Item No.	Report of the Interim Director of Planning, Regeneration & Public Realm	
Address:	14 LARNE ROAD RUISLIP	
Development:	Demolition of an existing 2-bed bungalow and erection of a new 4-bedroom bungalow with habitable roof space, including side dormer, raising the ridge of the main roof, roof lights and solar panels.	
LBH Ref Nos:	57311/APP/2022/3104

It is therefore recommended that this application is refused for the reasons set out in this delegated report.

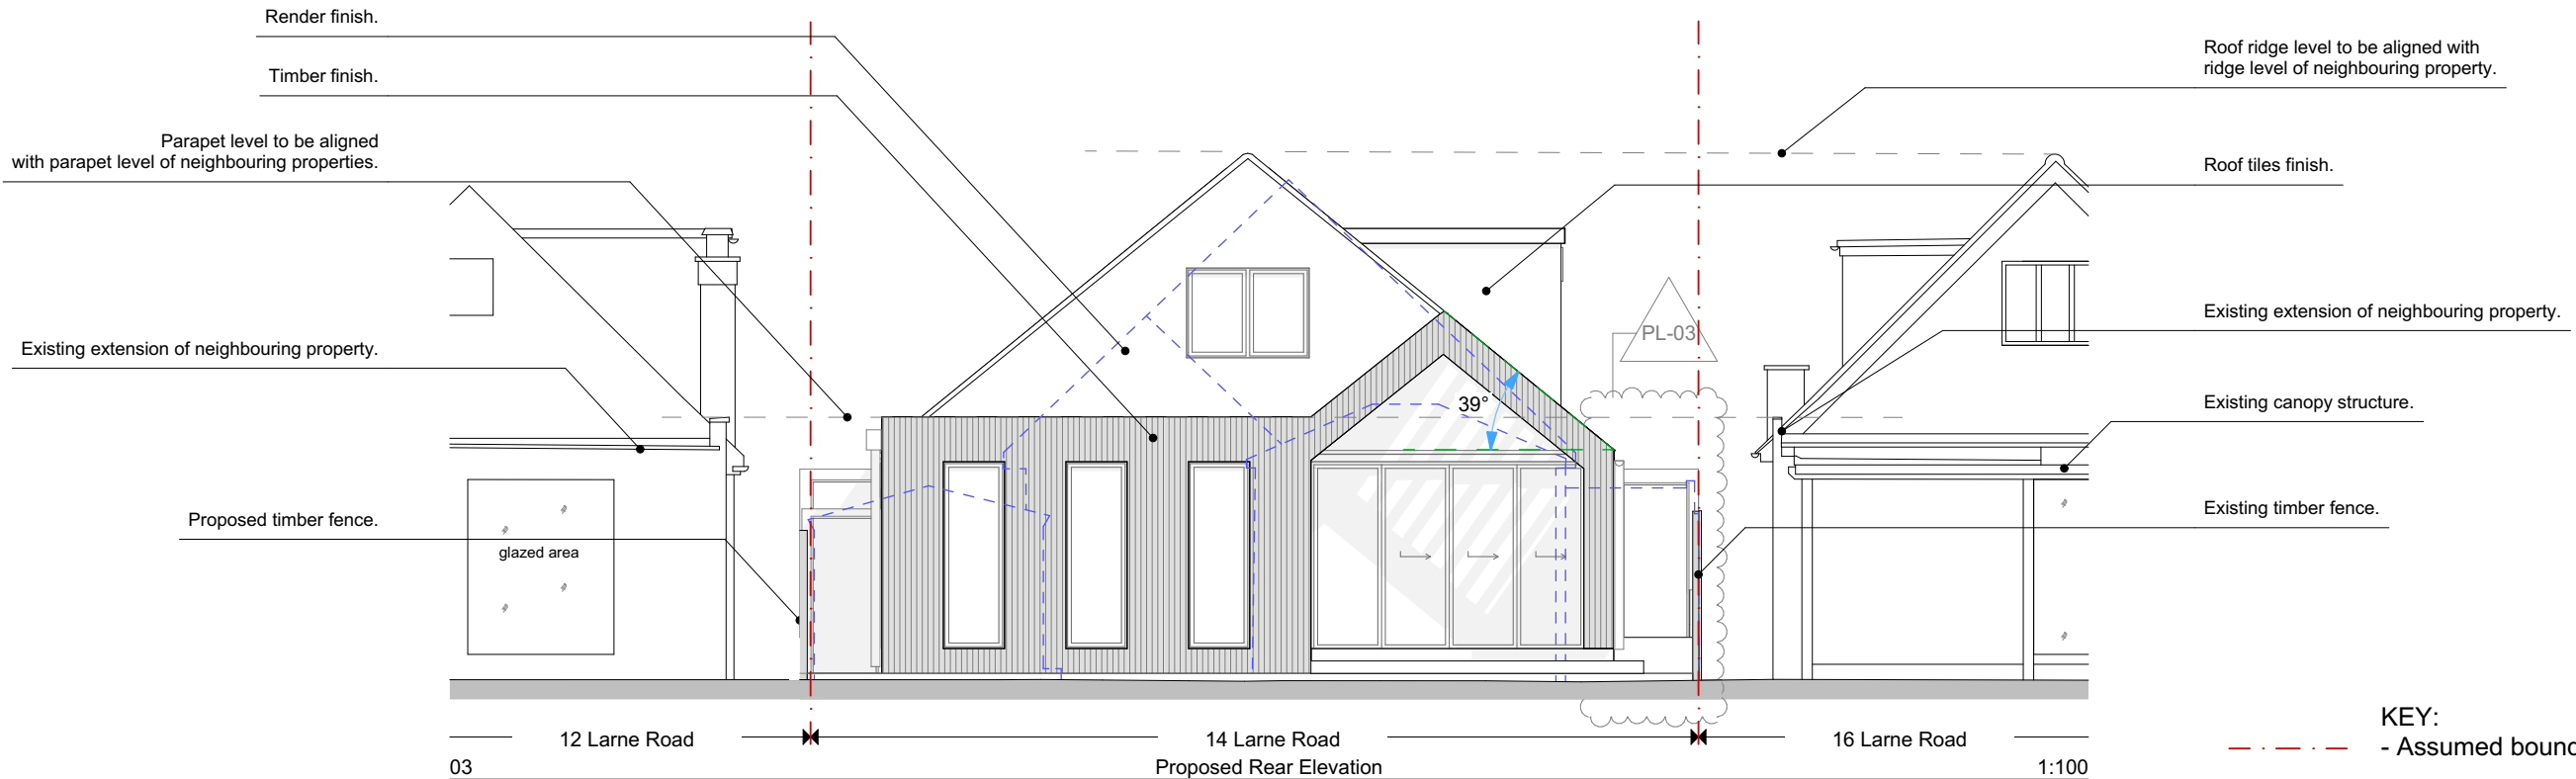
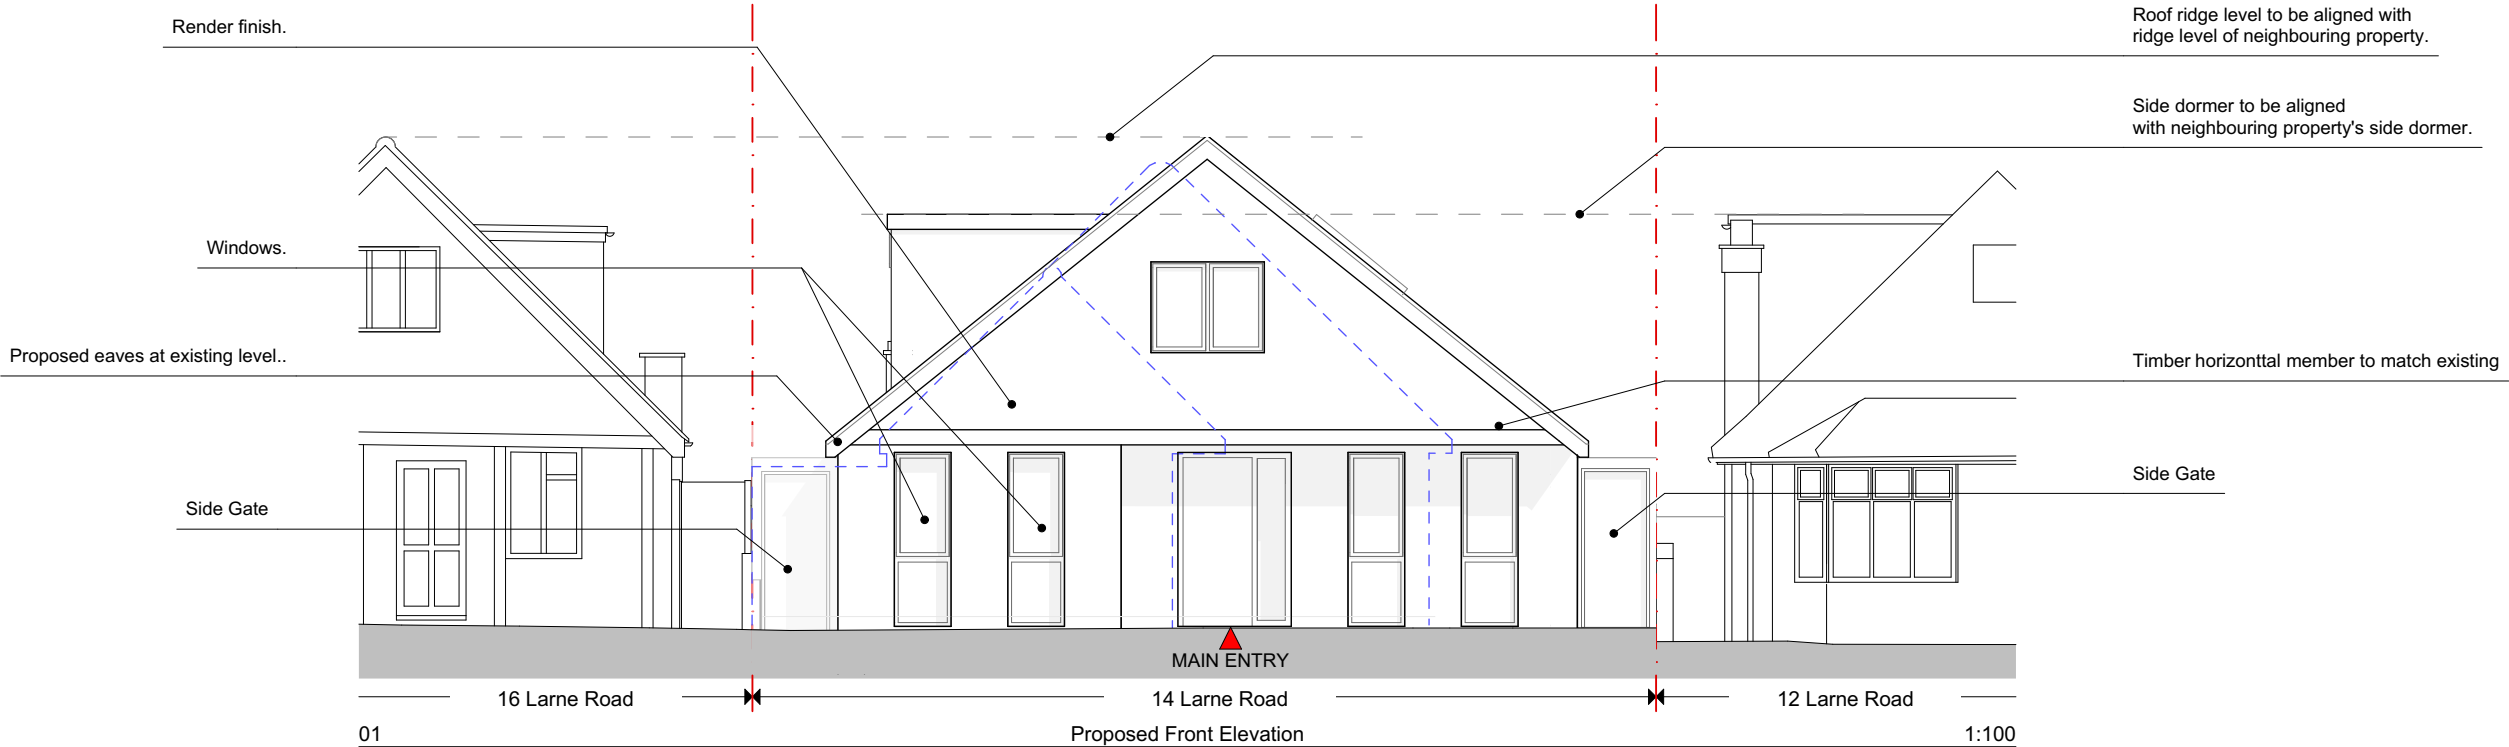
No. 16 contains an existing dormer and roof light in its side roof profile facing the application site. The proposed side dormer would face towards the existing side dormer at No.16, both of which serve bedrooms. Due to this relationship, it is considered that the proposal would result in a loss of outlook, sense of enclosure and overbearing impact on No.16. Furthermore, the proposed side dormer windows would give rise to a loss of privacy for the occupiers at No.16 (both real and perceived). It is considered that the size and height of the proposed side dormer windows would not mitigate the loss of privacy (both real and perceived) that would be caused. It cannot be argued that the proposed side dormer window could be conditioned to be obscure glazed as this would unacceptably prejudice the level of outlook and light afforded to the future occupiers of this proposed bedroom.

The proposed dwelling would measure approximately 10.9 metres wide, 18. 5 metres deep and 6.5 metres high. The front and rear elevations of the proposed dwelling would be predominately clad in timber, which would not match or complement the existing street scene on Larne Road. As a result, the proposed dwelling would appear as an incongruous form of development that would

The proposed angled wall at first floor level pays little regard to the surrounding built environment where there is a degree of symmetry intact between the proposed in this section of Larne Road, in terms of their front building lines.

It is considered that the proposed angled wall would appear as an awkward and discordant feature that would cause harm to the character of the area and street rhythm.

When taken together, the choice of material (including the timber shutter windows), angled first floor, various roof profiles and solar panels, would create a 'busy appearance' that would not respond well to, and would appear wholly out of character with the surrounding street scene.

The submitted proposed site plan shows that the proposed canopy would lead out towards a patio area. It is unclear from the submitted drawings as to the height and appearance of this patio area as the proposed elevations appears to show external steps in this locations. However, this matter would have been addressed through the imposition of a planning condition, if this application had been recommended for approval.
